Our Ref: AL/68/17/HH
Your Ref:

Town & Country Planning Act 1990 (as amended)
Town & country Planning (Development Management Procedure) (England) Order 2015
Application for Planning Permission for Works or Extension to a Dwelling

Development Loft conversion with dormer window & single storey rear extension.
Location 4 Elm Tree Cottages Nyton Road Westergate

BLOCK PLAN / SITE PLAN

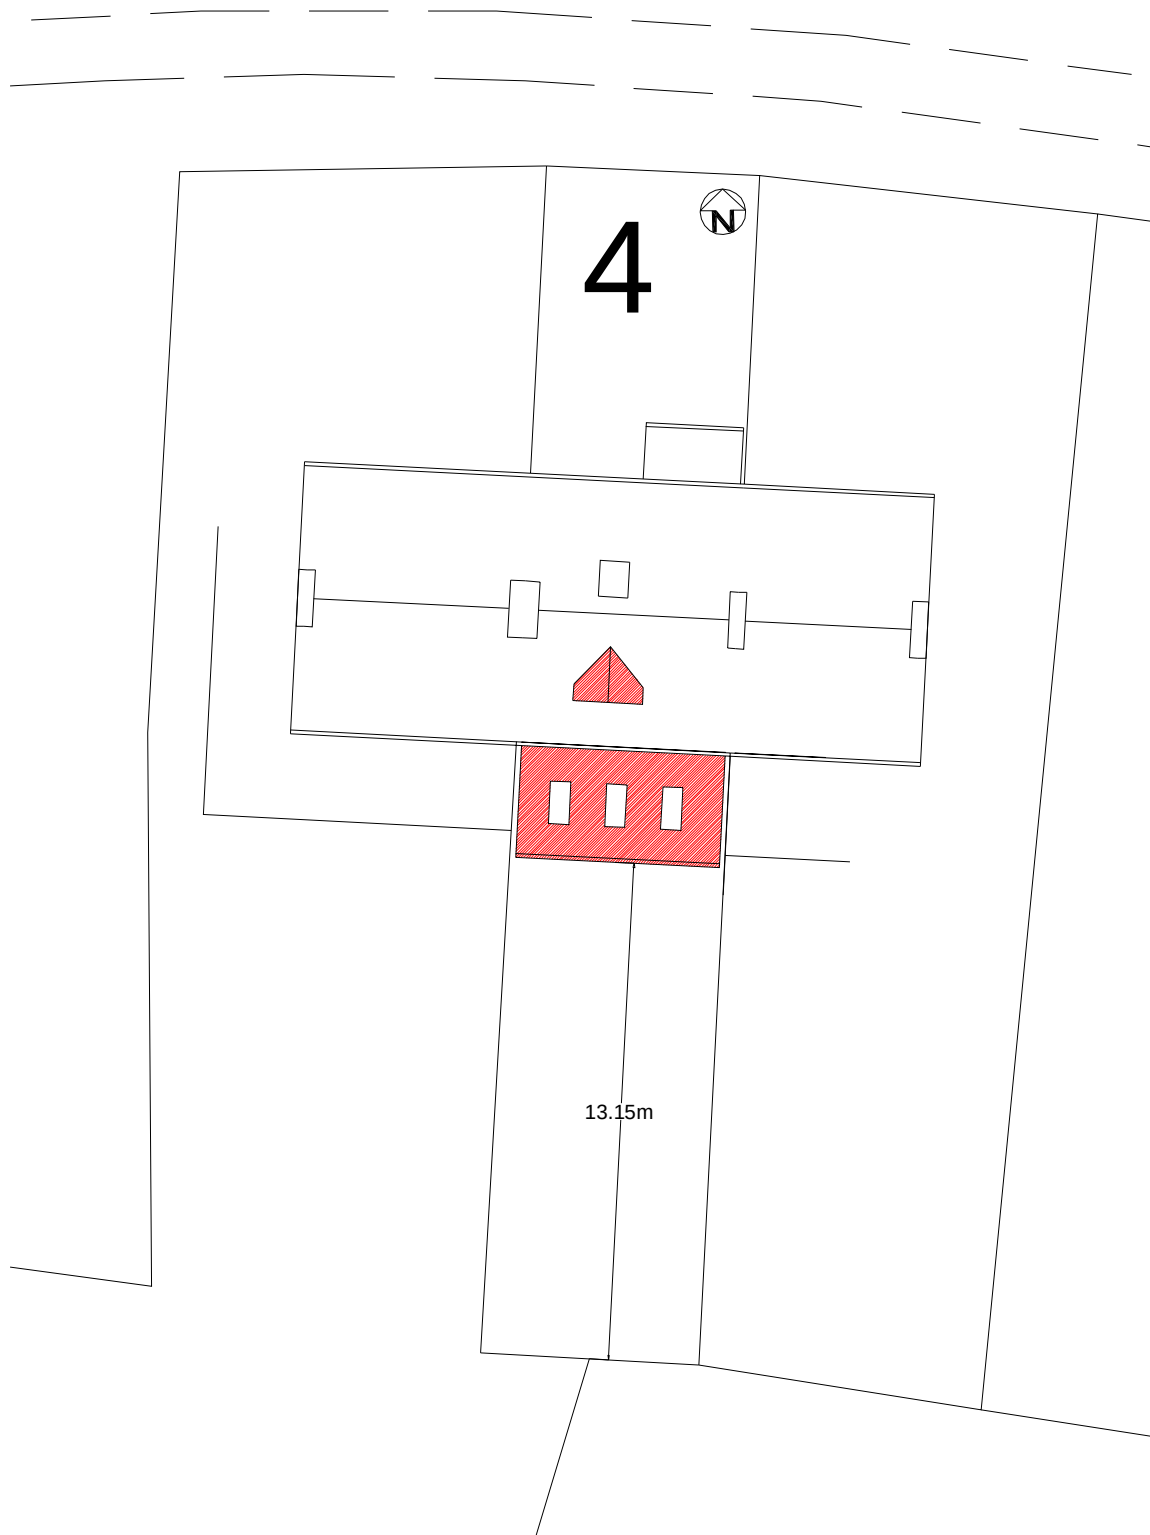
Block Plan Amend

Please submit 1 electronic or 3 paper copies of a block/site plan at a scale of 1:500 or 1:200. Further details of what must be included on the plan can be found in the National Validation Requirements. Please clearly highlight all proposed works and provide measurements from the proposed rear extension to the site boundaries.
